## Meeting Minutes - Peer Review Process: Architecture Design Review Panel

### Rozelle Village

Redevelopment of Balmain Leagues Club - Victoria Road, Waterloo Street and Darling Street, Rozelle  
V2: 051211

<b>Date:</b>	28 November 2011
<b>Meeting No:</b>	Meeting 3: Design Development Presentation
<b>Location:</b>	Rozelle Village Information Centre, Rozelle
<b>Time:</b>	4.10pm
<b>Attendees:</b>	<b>Panel Members</b> Ken Maher (KM) – Chairman, Hassell Alec Tzannes (AT) – Director, Tzannes Associates (arrived 4.15pm) Helen Lochhead (HL) - NSW Deputy Government Architect (arrived 4.45pm) Tony Caro (TC) – Director, Tony Caro Architecture <b>Property Developers</b> Ian Wright (IW) - Rozelle Village Pty Ltd Alex Yasumoto (AY) - Rozelle Village Pty Ltd <b>Architects</b> Frank Stanisic (FS) - Stanisic Associates Jason Nowosad (JN) - Stanisic Associates (scribe)
<b>Apologies:</b>	
<b>Attachments</b>	Design Development Presentation

ENVELOPE STUDIES - OPTION A

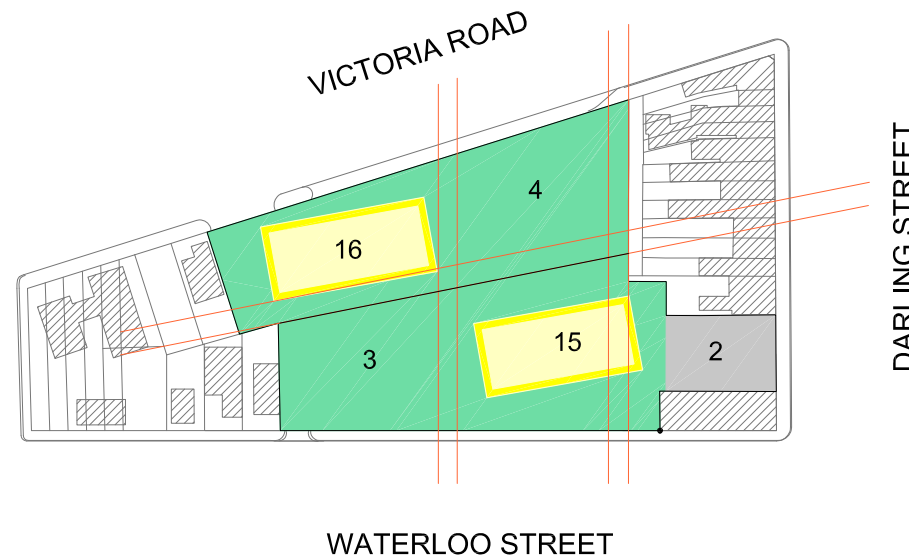
- FS commented that in all option there is approximately 8,000sqm of non-residential uses in the basement.
- FS tabled option A:
  - FS commented that this option accompanied the PEAR and that there is no adjustment of the podium to the streets.

ENVELOPE STUDIES - OPTION B

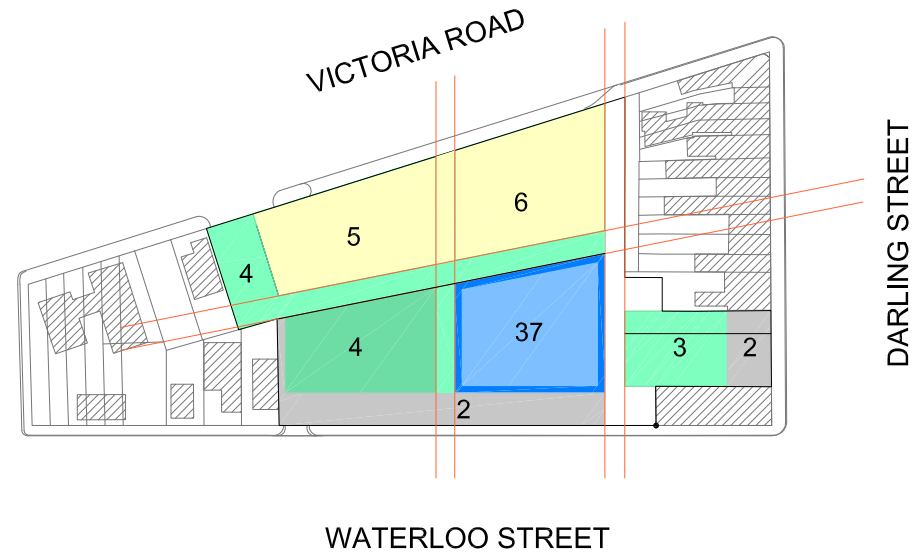
- FS tabled option B:
  - FS commented that this option is a refinement of a previously shown proposal, but with a stepping building along Victoria Road, rather than had a flat top.

- HL questioned the footprint area of the high-rise building in this option. FS confirmed that the footprint is approximately 1,000sqm GFA, but stressed that the form shown in a block form and not a building.

- HL questioned how a footprint in excess of 800sqm could deal with bulk and scale. FS commented that this footprint is approximately the same footprint as Horizon Apartments – 184 Forbes Street, Darlinghurst. FS added that although the proposed footprint in the same, the type is a split block form, not a central core block form. FS commented that the split block form is one way of dealing with bulk and scale.

ENVELOPE STUDIES - OPTION C

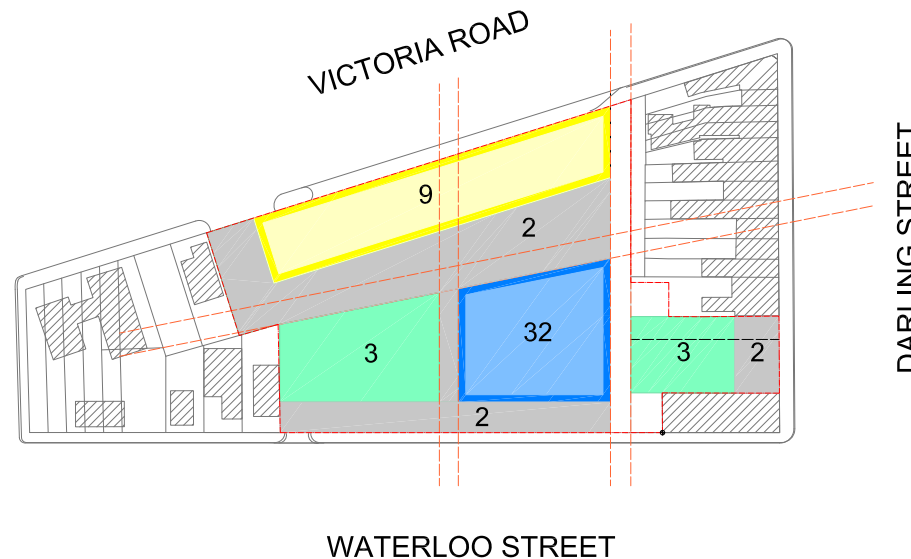
- FS tabled option C:
  - FS commented that this option is a variation to option B, but with a 9 storey block edge building along Victoria Road for residential.

- HL questioned the length of the building along Victoria Road. FS confirmed that this building is approx 90m long. KM added that this form could be two buildings that step down Victoria Road.

- FS commented that the first four storeys would be non-residential uses, including one full story for the Balmain Leagues Club.
  - HL commented that the form along Victoria Road could break above the four storeys so that the form could be scaled to the street.

- FS commented that it is proposed that there are loggias or ‘winter gardens’ for residential apartments, not balconies. HL questioned whether loggias would increase the bulk of the building. FS commented that through the use of glazing, you can articulate the form to reduce bulk and get variation in the facade such as Lumiere, 101 Bathurst Street, Sydney. FS added that double glazed units (DGUs) produce better environmental outcomes (acoustic/thermal) and have recently decreased in price and are now affordable.

ENVELOPE STUDIES - OPTION D

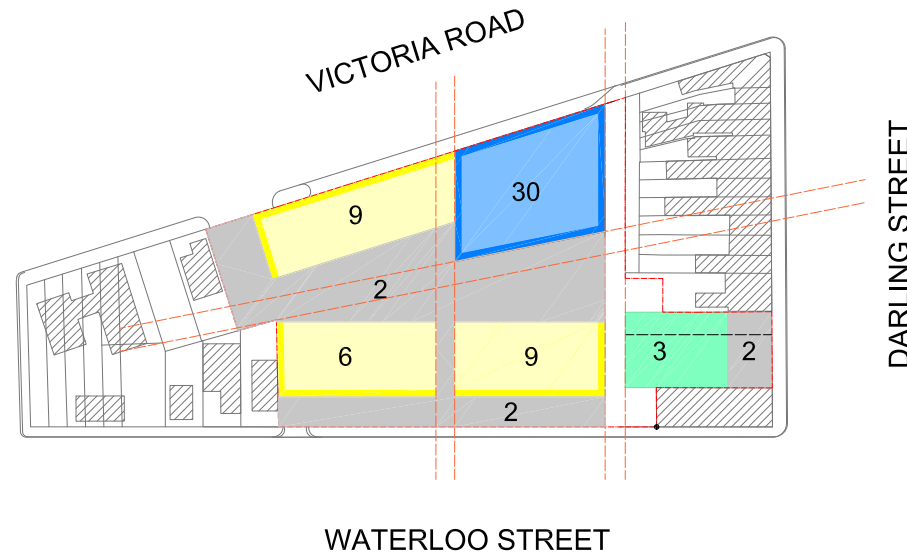
- FS tabled option D:
  - FS commented that this option moves the high-rise form to Victoria Road, decreasing the height of this building and increasing height of mid-rise forms along Waterloo Street.

- HL questioned whether the primary residential entry could be from the laneway adjacent to Darling Street. FS commented that the existing laneway is in fact an easement of adjoining properties is not part of the development site.

- TC commented that a criticism of this option is that there is increased bulk and scale along Waterloo Street. HL disagreed, commenting that the mid-rise form is setback from Waterloo Street and the low-rise form along the street is an appropriate scale.

- TC commented that the high-rise form on Waterloo Street is better with mid-rise form along Victoria Road.
  - HL requested that additional views are shown from street level.

- KM commented that the the high-rise form is not as dominant as the high-rise form in option B as the footprint is smaller.
  - AT commented that in Sydney, there are a number of larger buildings located adjacent to larger infrastructure i.e. Macquarie Street, Pacific Highway, St Leonards, Parramatta Road, South Dowling Street – but that they were not really good models.

ENVELOPE STUDIES - OPTION E

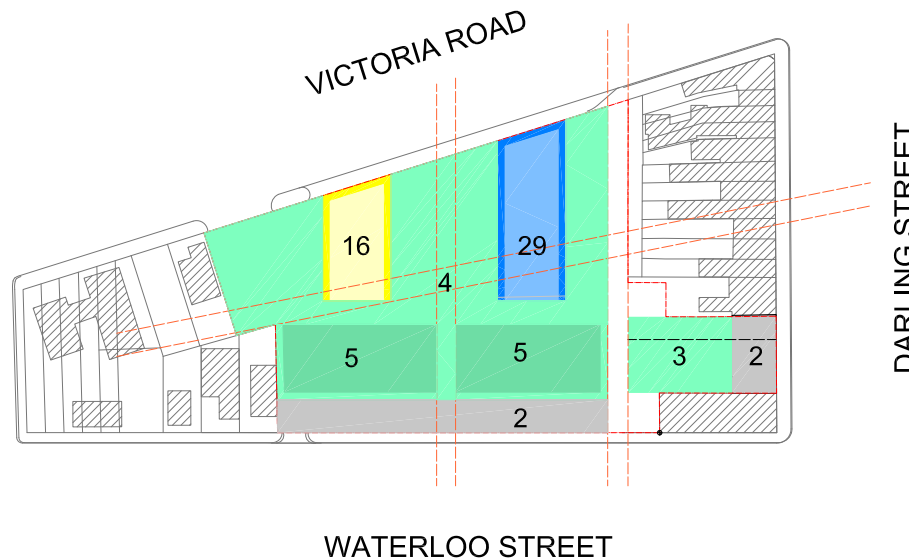
- FS tabled option E:
  - FS commented that this option was based upon the site specific DCP for the site but with increased floor space. FS added that this option maximises solar access to Waterloo Street with two high-rise forms, the taller form adjacent to Darling Street.

- KM commented that the central space between the two forms will receive solar access from the east and west, in the morning and afternoon.
  - TC questioned the depth of the forms. FS commented that the forms were approximately 14m deep and each with a footprint of approximately 400sqm.

- KM commented that a building type in this form could be a gallery type. TC added that the building type could also be a central core.
  - TC commented that this option is much more slender than other options and has a better interface with Victoria Road. TC added that the lower form could be turned 90 degrees, parallel to Victoria Road. HL agreed that it would be better to pursue two different forms, not a high-rise form and a mini-me.

- HL commented that she was more comfortable with a single high rise form, but found this option with two high rise forms compelling due to their smaller footprints and slender appearance.

- KM commented that a dominant high-rise form should be located on the north-south axis. KM added that if you take option E, the high-rise form should be rotated to be north-south and the mid-rise form should be rotated to face Victoria Road.

ENVELOPE STUDIES - OPTION G

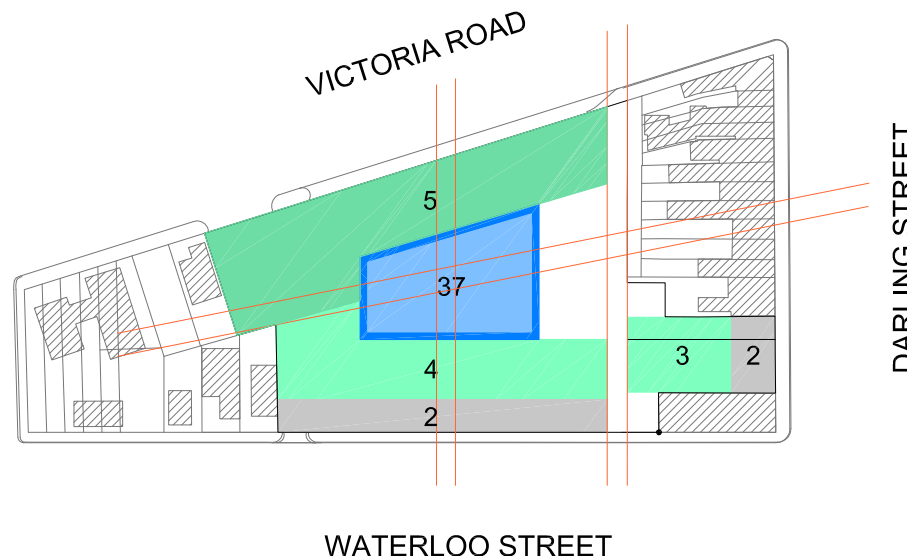
- FS tabled option G:
  - KM commented that the residential address did not need to be from Waterloo Street.
  - TC commented that the entry forecourt was interesting and that the residential address in this option is from Waterloo Street and Victoria Road.
